15879

**Conditions of development consent for the Sydney Metro Martin Place Station Precinct
SSD 9270 – North Site**

Condition B5, B6 and B7 discharge request #2 – Design excellence and design integrity review

Figure 1 Approved placement of louver

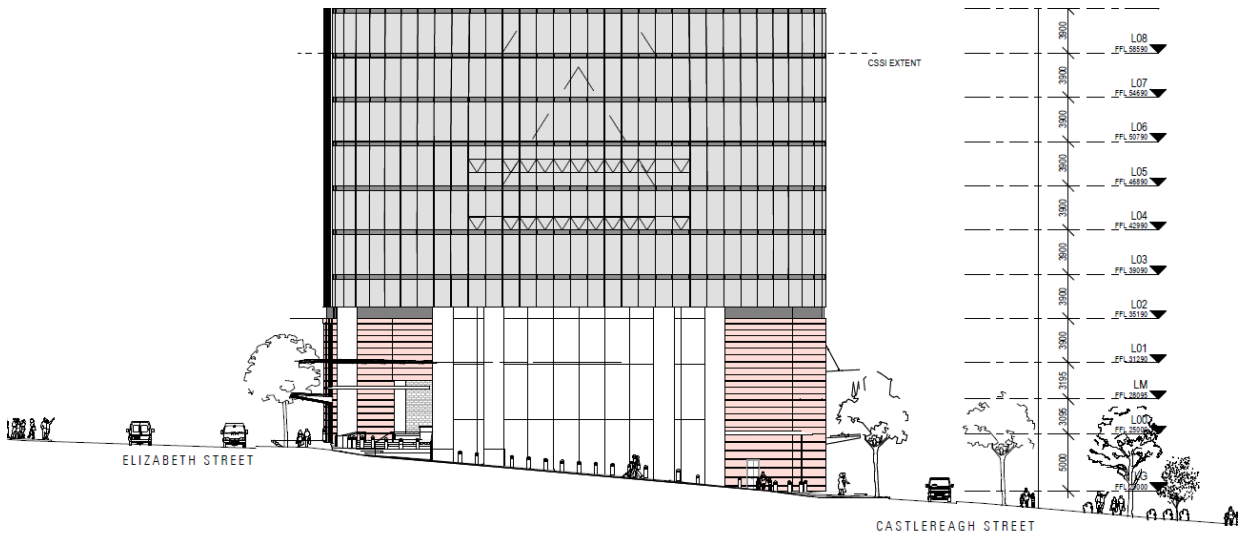
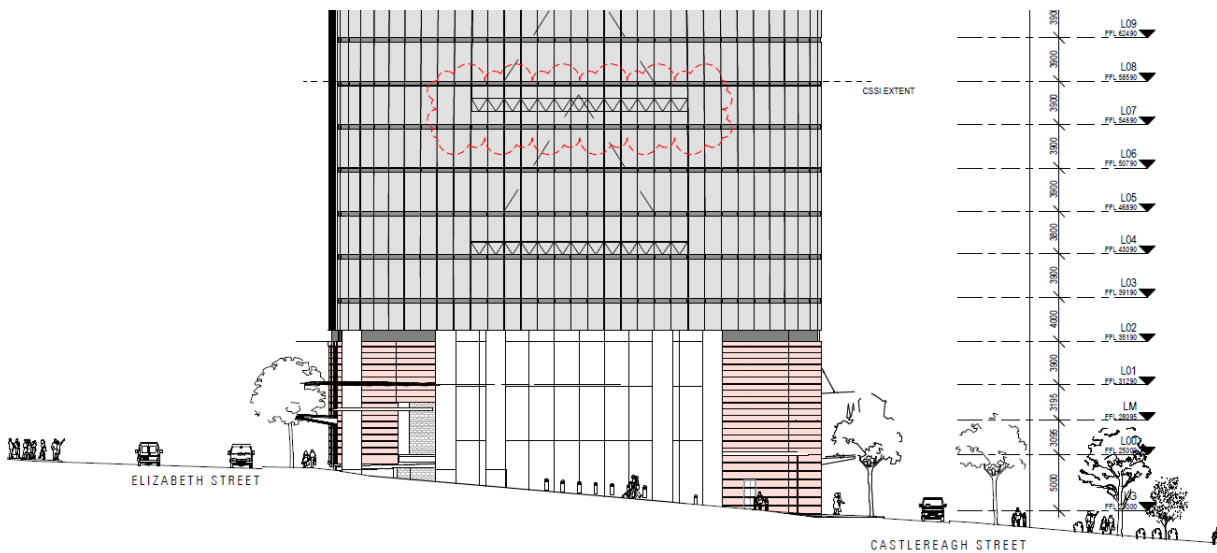
Appendix reference	Design change	OSD DRP engagement approach
App A Reference 6	Relocation of louvres from Level 5 of the northern facade to Level 7. The louvres allow for free air to return to service the office floor.	OSD DRP review is not considered necessary on the basis the proposed change is minor and constitutes only the relocation of an approved louvre. The modification will have a negligible impact on the overall northern façade design.
App A Reference 7	Introduction of Structural infill slabs to the atrium voids on Levels 19, 22 and 25.	OSD DRP review is not considered necessary on the basis the proposed changes are wholly internal and will not result in any changes to the exterior of the building.
